Detailed Objection to Proposed Fort Street Public School Development to Increase Building Heights

3. Proposed Changes – new storey to be added to Bldg “J” (SSD-10340-Mod-1)

Elevations

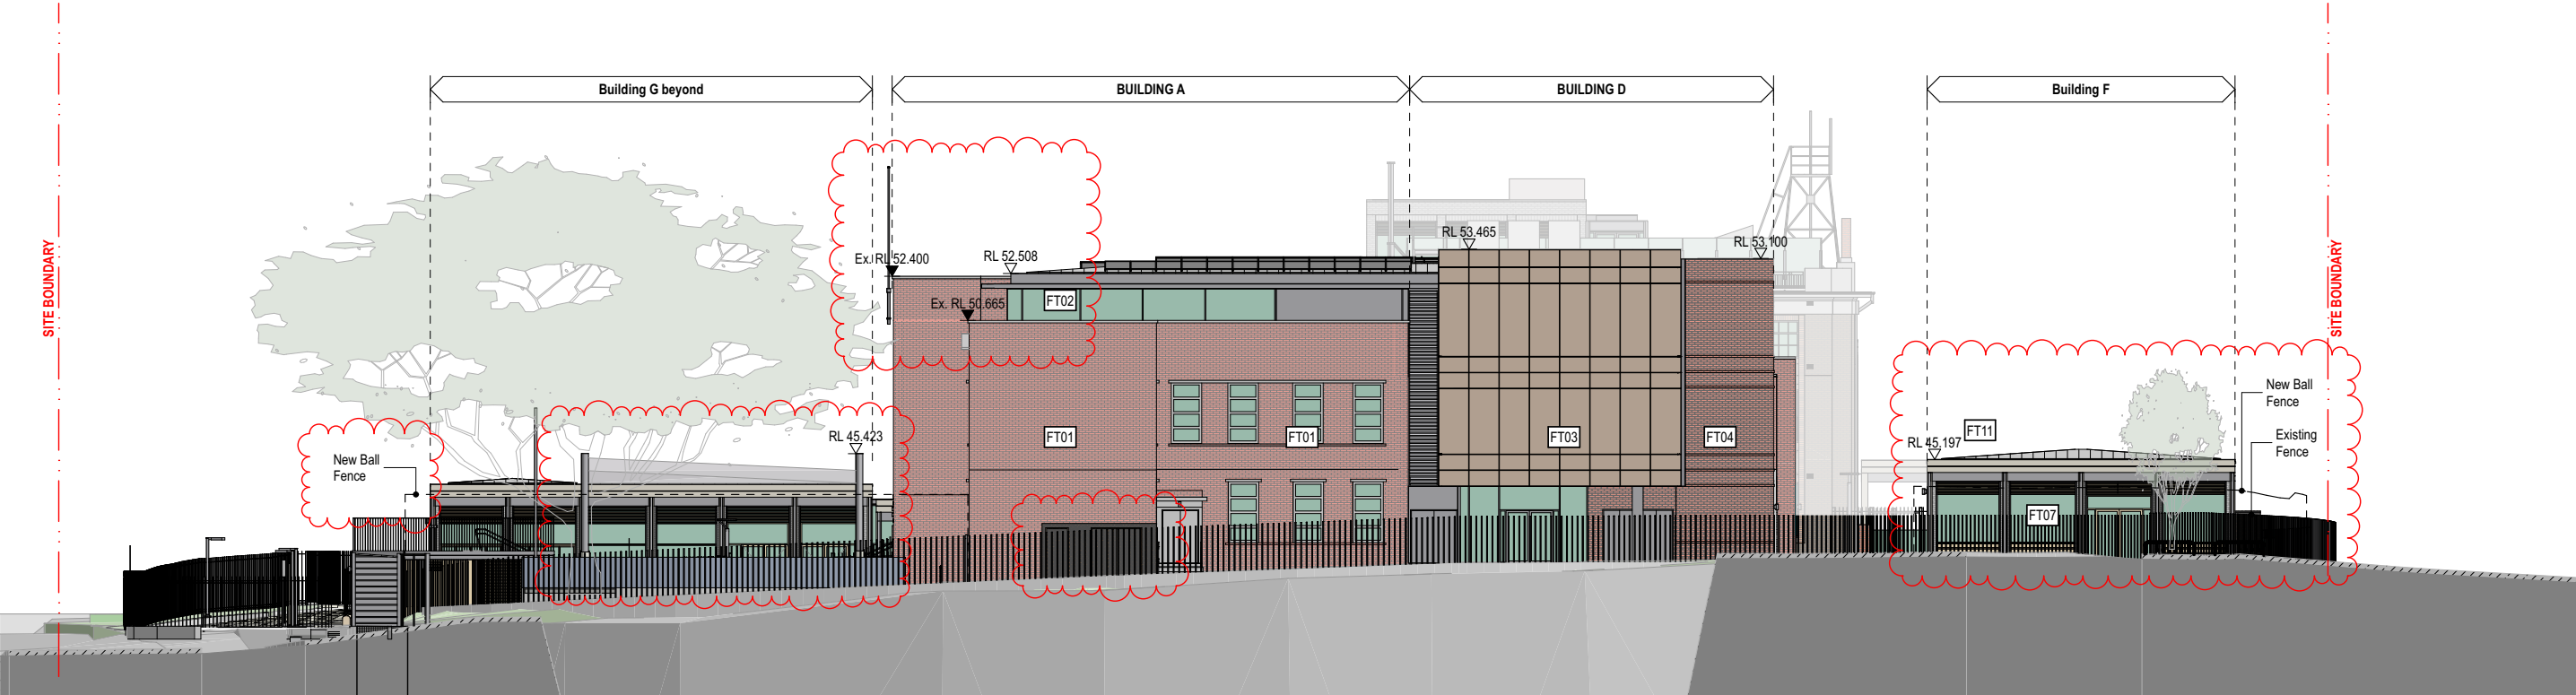
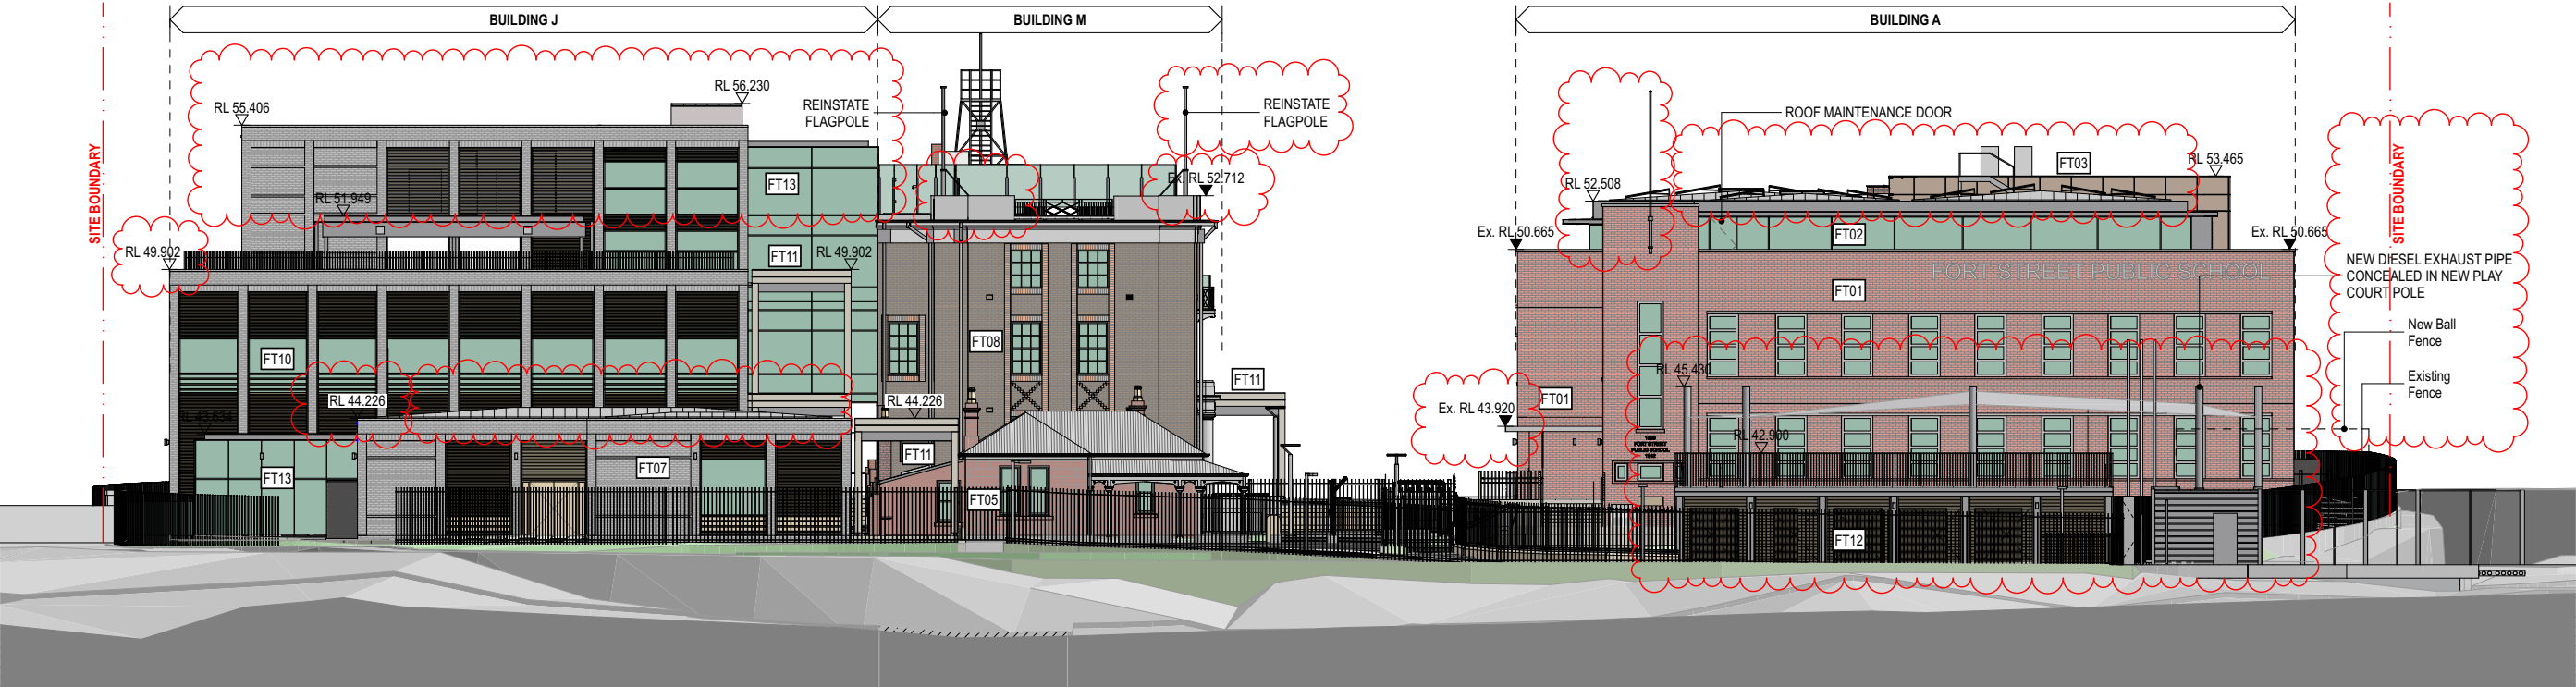
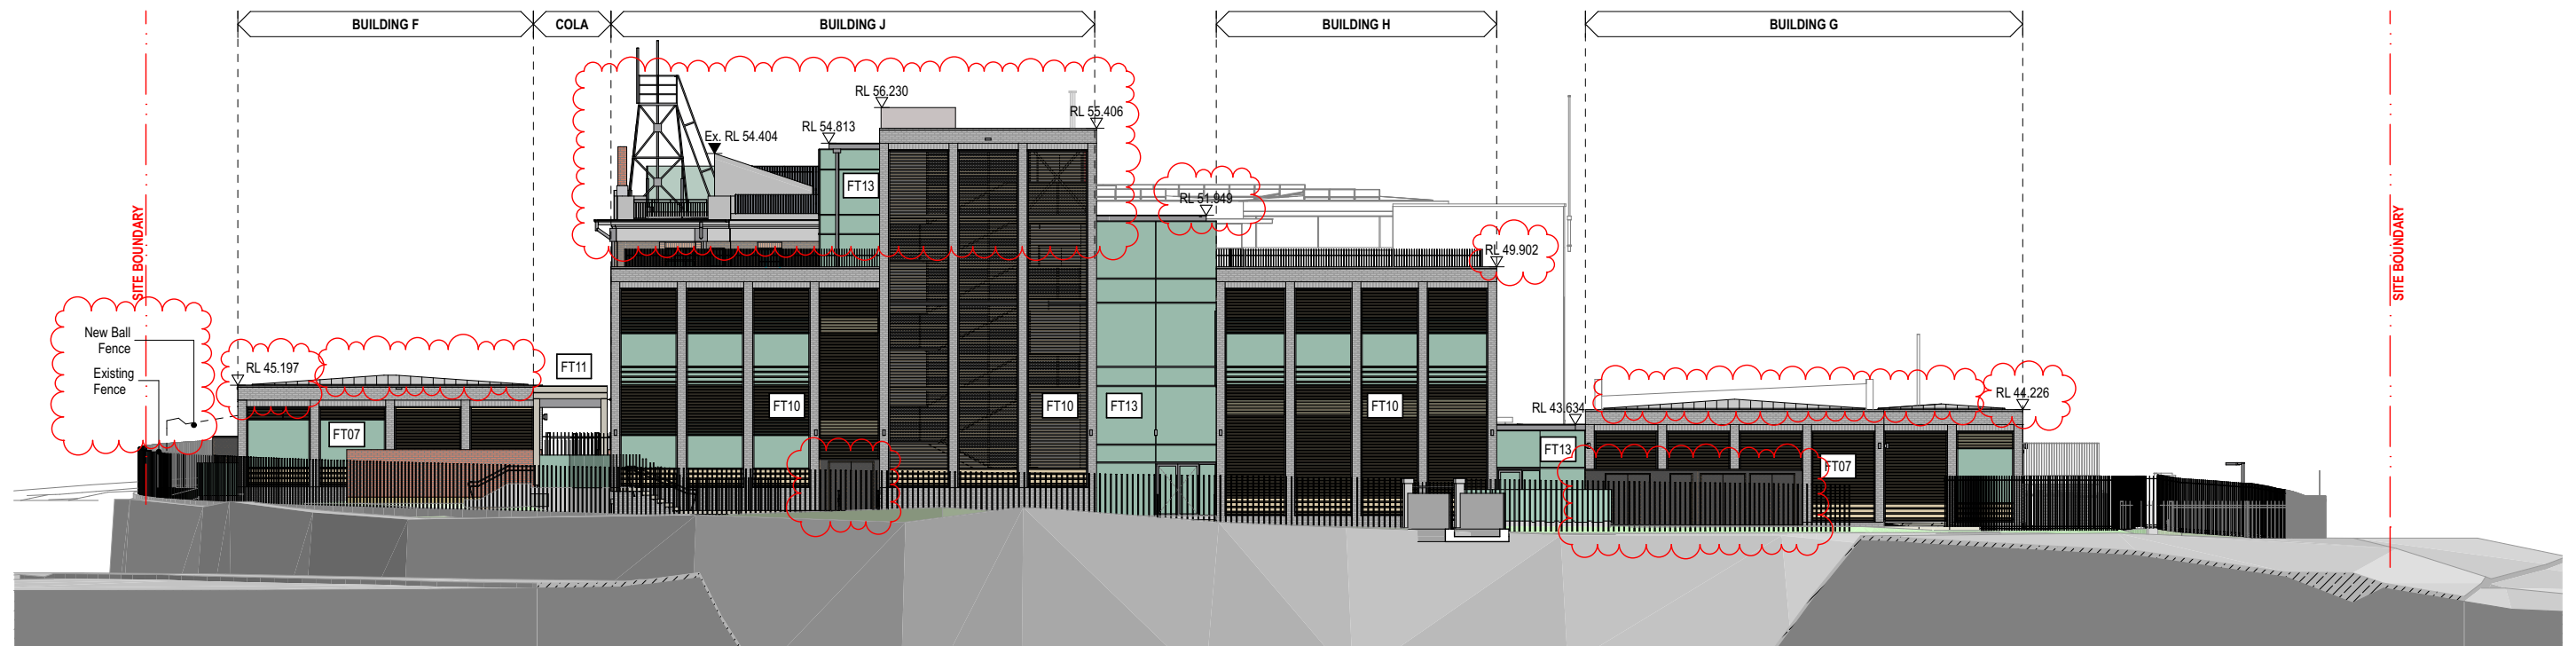
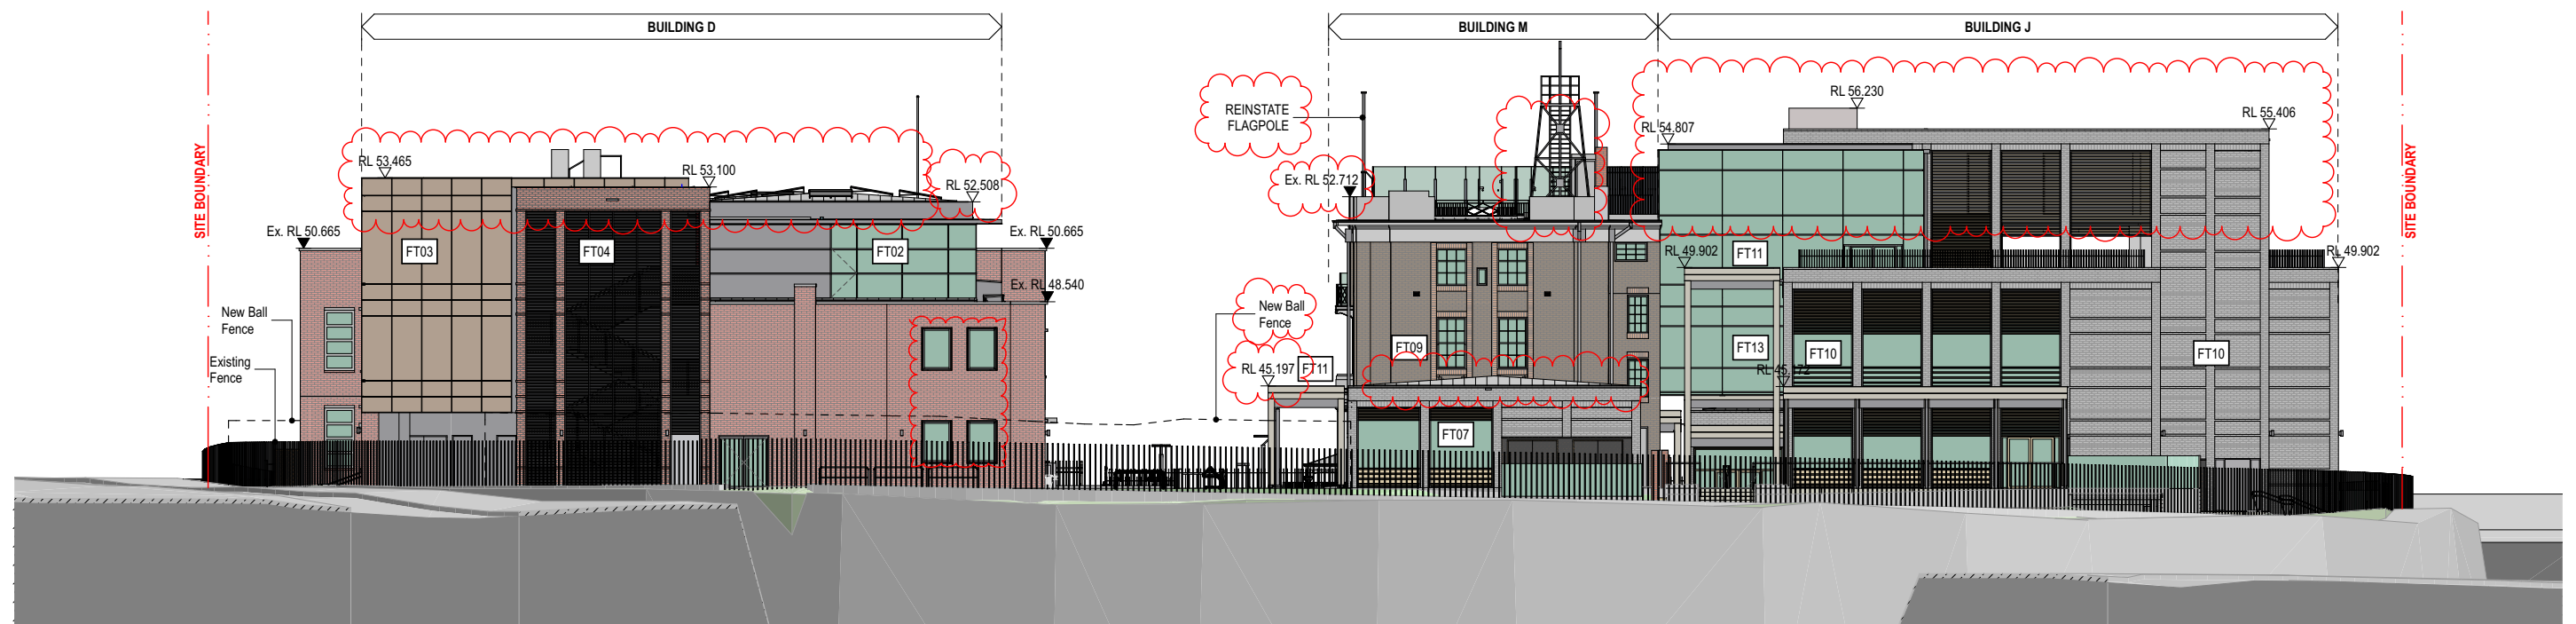
In Appendix B - DA-3001 Elevations North East, in the following link the overwhelming size and bulk of Building J compared to Met Building can be observed:

How can Curio Projects on behalf of School Infrastructure NSW say that the increased building height of Building “J” is compliant to their own Conservation Management Plan (CMP) policies when it is proposed that the new height is well above the parapet of the Met Building? Building J is much larger, the general bulk much bigger and it very clearly exceeds the height of the Met building, leaving the Met building to no longer be the most dominant building on site in terms of both height and architectural form.

The following diagram also shows that the above policies are not met. Notice how Building “J” compared to Met Building is well above the parapet of the Met building:
